Appeal Decision

Appeal Ref: APP/C3810/D/25/3362664

1 Elmer Court, Elmer, Middleton-on-sea, West Sussex PO22 6JT

- The appeal is made under section 78 of the Town and Country Planning Act 1990 (as amended) against a refusal to grant planning permission.
 - The appeal is made by Mr & Mrs Baritsch against the decision of Arun District Council.
 - The application Ref is M/100/24/HH.
 - The development is single storey rear pergola and first floor rear balcony with sliding doors.
-

05 SIDE (WEST) ELEVATION:

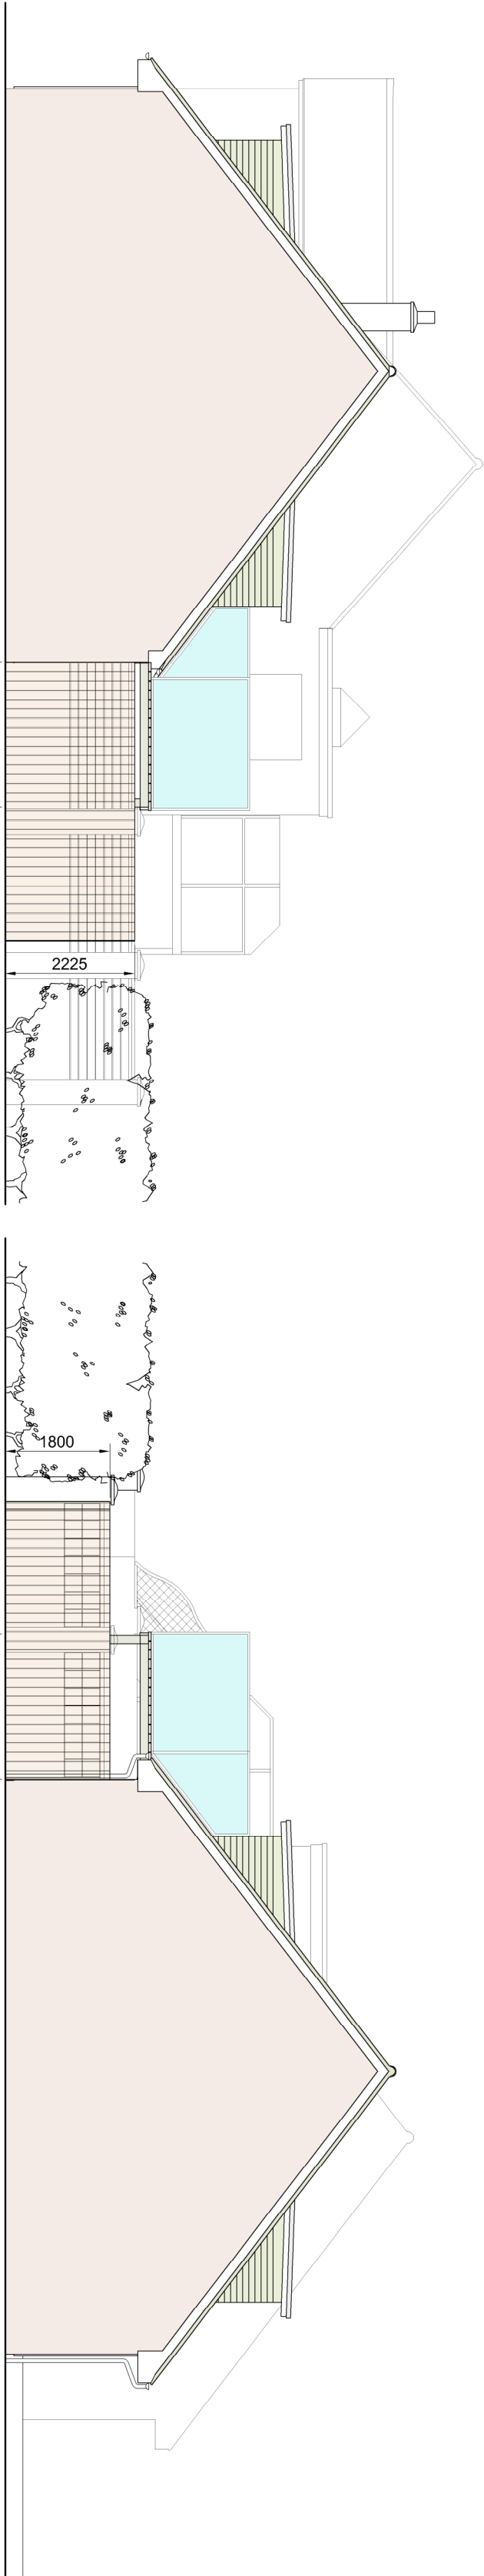
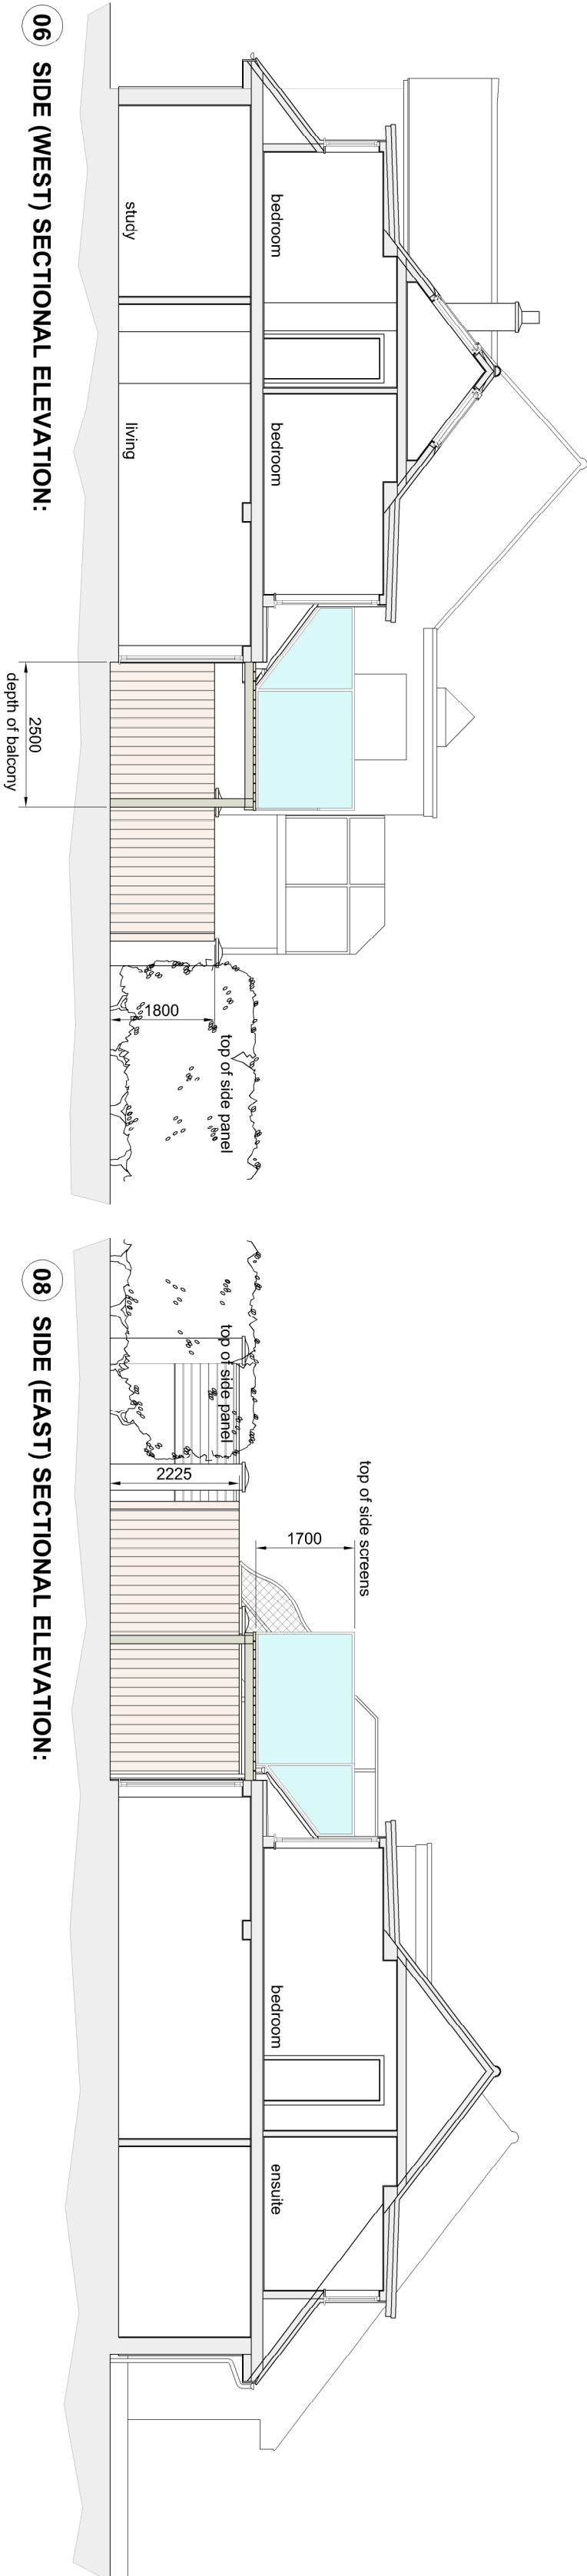
5. The appeal site lies on the southern side of Elmer Court and comprises a detached dwelling with its rear elevation facing the beach. The development includes a full-width single-storey balcony and pergola constructed from oak beams and timber planks, with sliding doors installed to the property at the rear at first floor. While the balcony and pergola have been erected, the balcony timber screen and railings remain incomplete.
6. From my site visit, I observed other full-width balconies at single-storey height in the area. However, these were either lightweight metal structures with slender

posts or positioned atop of rear extensions, appearing more integrated and visually sensitive. In contrast, the appeal scheme, due to its extensive use of timber, appears bulky and dominant.

7. The proposed pergola structure, although described as a pergola, does not reflect the typical open-roof form associated with such features. Instead, the roof of the pergola is fully timbered and closely resembles the balcony in both design and construction. Its solid and enclosed appearance contributes to a greater sense of mass and bulk, which is visually at odds with the character of the property.

8. The combined massing and materials of the balcony and pergola result in an incongruous addition that overwhelms the rear elevation of the host property. While balconies are a recognised feature of the area, the appeal development lacks the design subtlety seen in other nearby examples and fails to respect the character of the host property.

12. It was evident that the timber privacy screen installed at ground floor level extends above the existing boundary wall and rises beyond the height of a standard 1.8 metre close board fence. This creates a tall and visually solid structure that dominates No. 2 Elmer Close. The height and bulk of the screen result in a pronounced sense of enclosure, which I consider to be harmful and overbearing to the garden and rear-facing rooms of that property

13. As the pergola does not reflect the typical open-roof design and sides as expected of such structures, its solid timber construction, lack of openness, and projection beyond the rear elevation of No. 2 Elmer Close results in an overbearing relationship with this neighbouring property. This causes an unacceptable impact on the living conditions of its occupiers.

15. From the appeal balcony, I observed views into the garden of No. 2 Elmer Close and No. 4 The Hard. While this raises concerns regarding overlooking, I find that appropriate screening, such as obscure glazing could mitigate these impacts. Such
